<b>Application Ref:</b>	3/2025/0713			 <b>Ribble Valley Borough Council</b> <a href="http://www.ribblevalley.gov.uk">www.ribblevalley.gov.uk</a>				
<b>Date Inspected:</b>	06/11/2025	<b>Site Notice:</b>	N/A					
<b>Officer:</b>	MC							
<b>DELEGATED ITEM FILE REPORT:</b>					<b>REFUSAL</b>

<b>Development Description:</b>	Proposed change of use from C3 Dwellinghouse to C2 Children's Residential Care Home (solo occupancy)
<b>Site Address/Location:</b>	15 Caton Close, Longridge, PR3 3RH

15 Caton Close, Longridge, PRESTON, PR3 3RH, UNITED KINGDOM

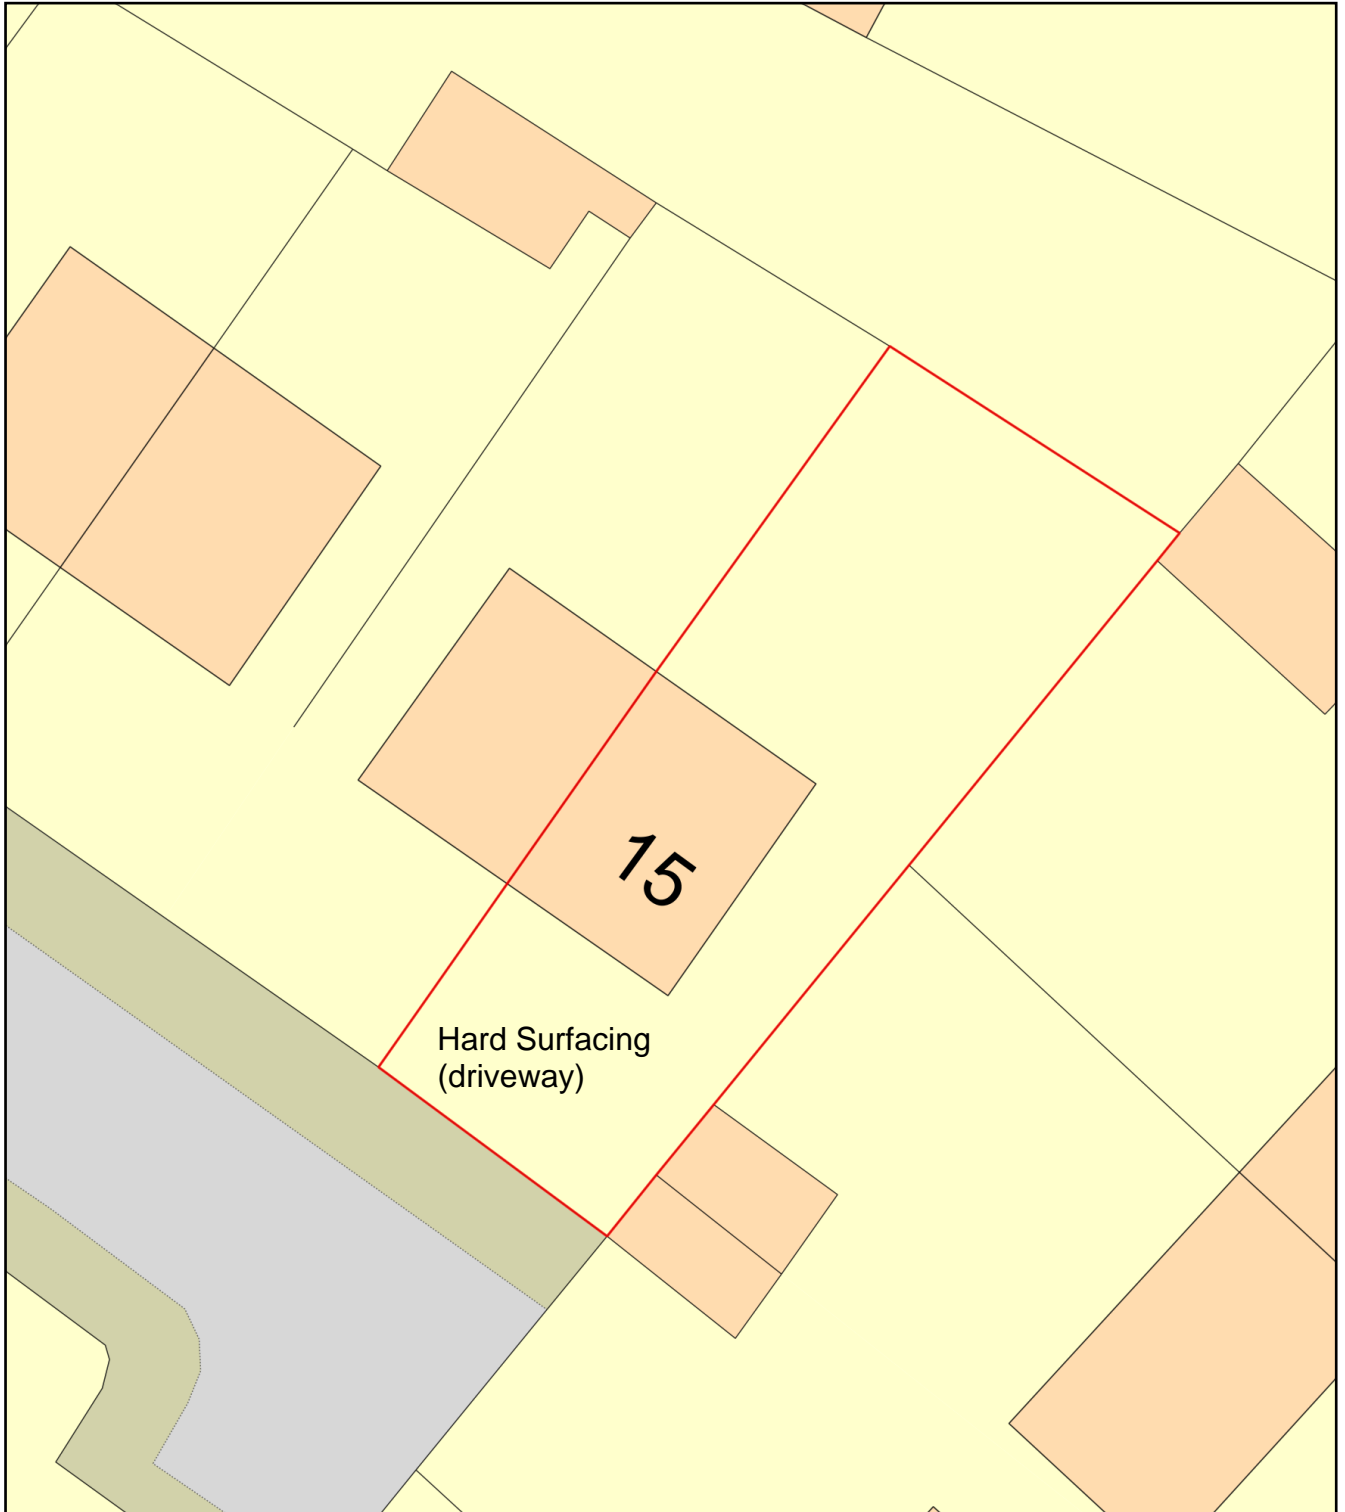
The Local Highway Authority have provided comments on the scheme and they note that whilst the existing driveway has been extended internally, the vehicle crossing situated within the highway has not been extended across the entire driveway opening. Therefore, to prevent damage to the footway and to protect the services beneath the footway, the existing vehicle crossing should be extended across the entire driveway opening. The Local Highway Authority consider that this would support acceptable access to off-street parking provisions.

With regards to parking provision, the Local Highway Authority are aware that there are 2 off-street parking spaces within the existing driveway. When considering how the site will operate as described within the Management Plan, they note that there would be 2 members of staff present as such off-street parking can meet the regular staffing needs. Whilst normally the LHA would require further off-street parking to be provided to support external visitors, given the size of the site, this is unlikely to be feasible. The Local Highway Authority consider that the road fronting the dwelling could cater for an additional on street parking space, which during the visit would block the use of the driveway and could be used by any short-term external visitors should it be required. As such, they consider that the effect of the development on the operation of the local highway network would be negligible. Whilst the local planning authority has concerns about increased pressure for on-street parking, due to position of the highways authority this concern is not considered to justify a refusal reason on highway safety grounds.

Subject to conditions to ensure the parking is retained and the dropped kerb is installed within three months of the permission being granted, the proposal is considered to accord with the above policies.
